Residential Structures P.C.
3410 N. Davidson St.
Charlotte, N.C. 28205
Phone 704-332-5469
www.residentialstructurespc.com

March 21, 2022

Re: Lot 7 Prince Place, Fuquay Varina NC

Per your request, I have completed a limited structural review of the roof truss and floor truss (second floor framing) layouts for the above referenced single family residence. More specifically, you have requested that I review the LVL beam calculation/ design sheets for the LVL beams located in the second-floor system for compliance with 2018 North Carolina Residential Code. Please see comments below.

Drawing file: SFD2110-0097 / LOT 7 PRINCE PLACE  FLOOR LAYOUT.pdf

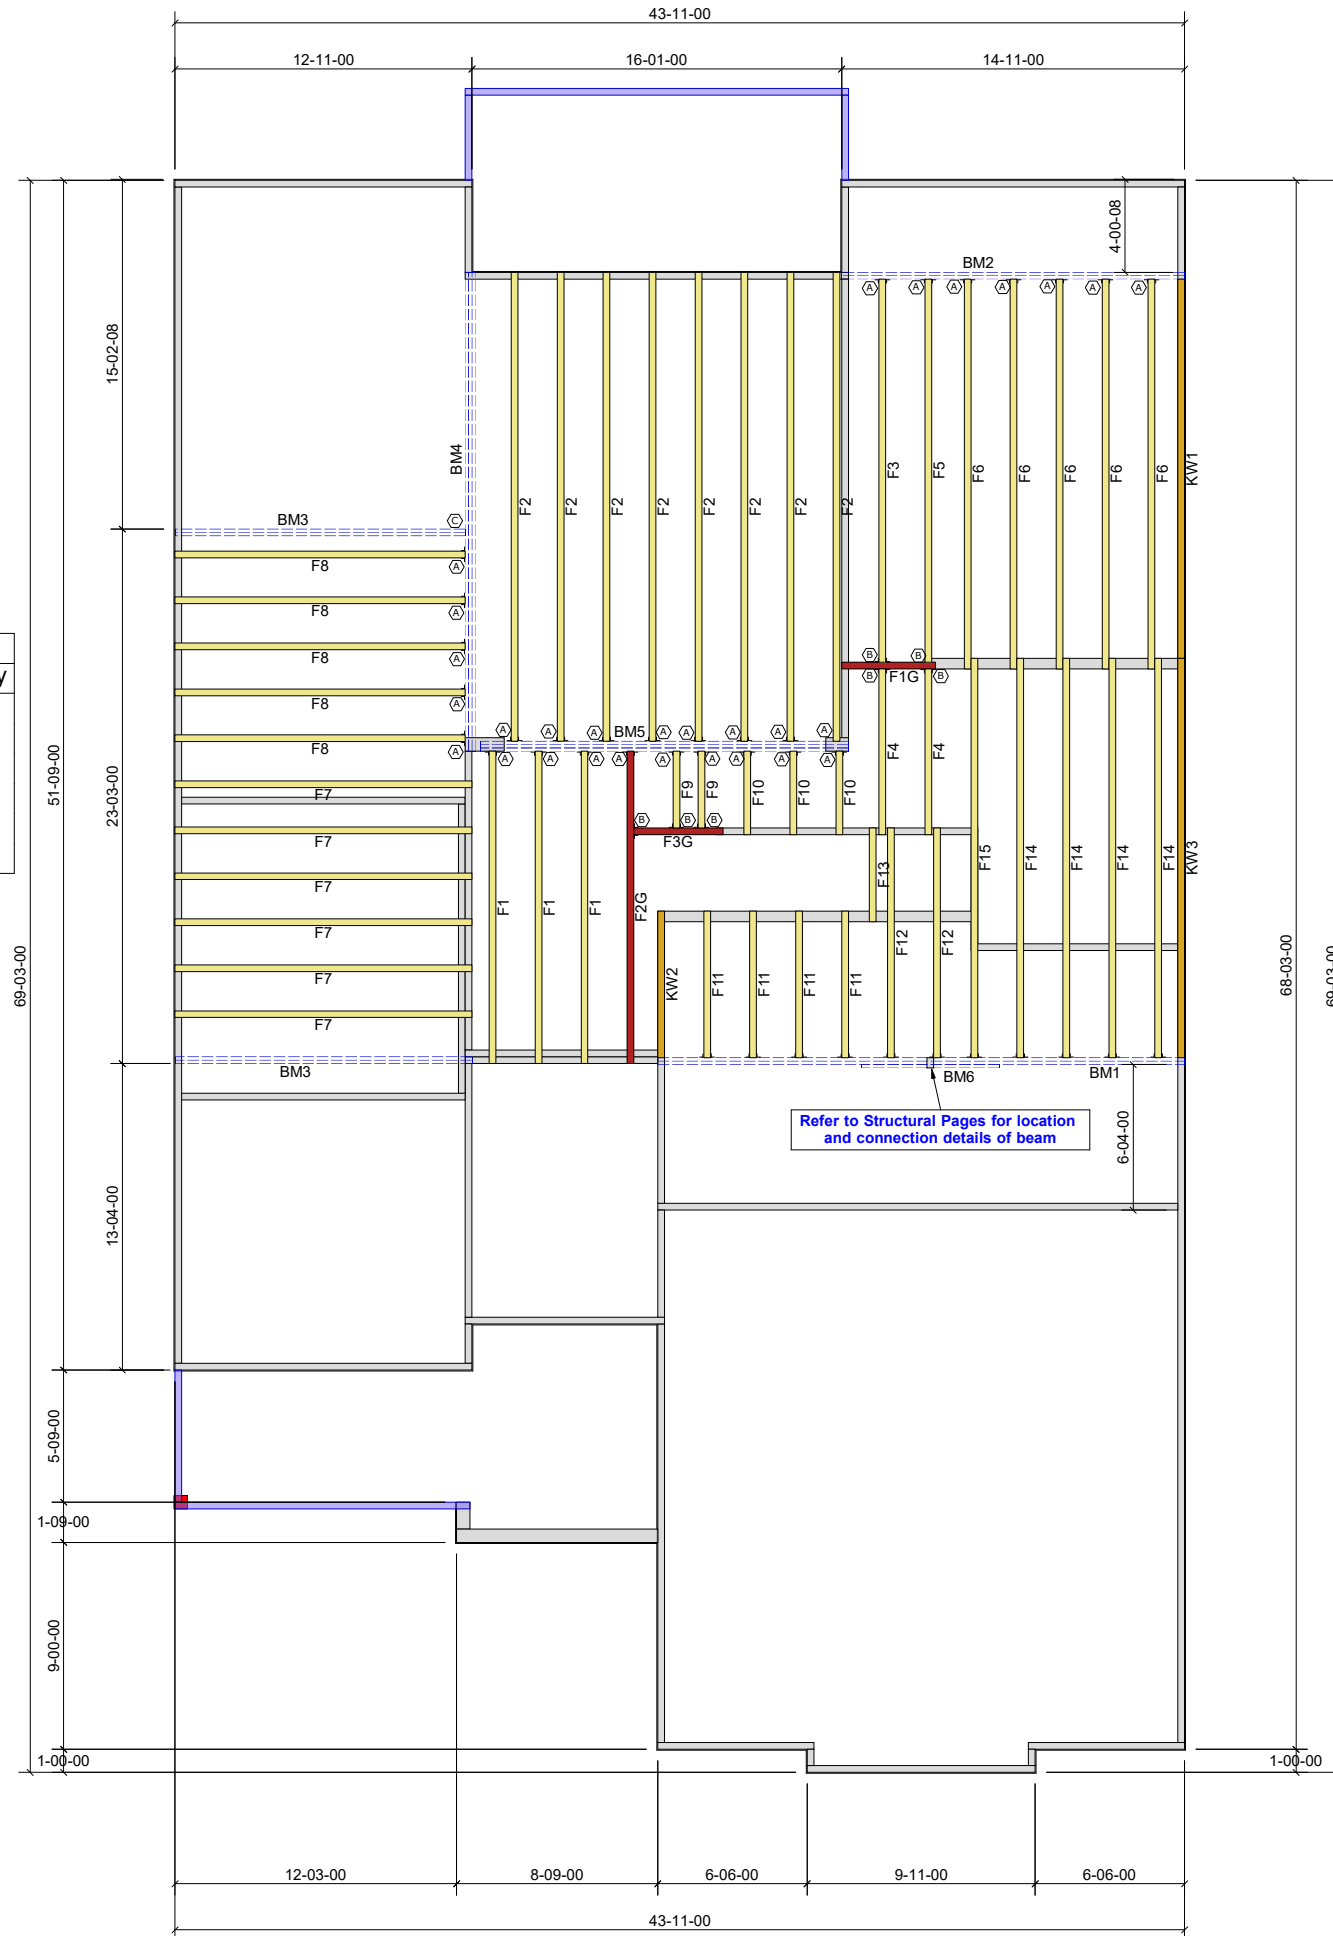
Based on information you have provided; I understand that the roof system (trusses) and second floor system will be framed in accordance with the roof and floor truss layouts you have provided (See Detail 1 and Detail 2 attached). Provided the framing follows the layouts, the LVL structural beams shown on the floor truss layout (Detail 2) and associated calculations (see LVL beam calcs, 10 pages total) will meet or exceed the structural requirements of the 2018 NCRC.
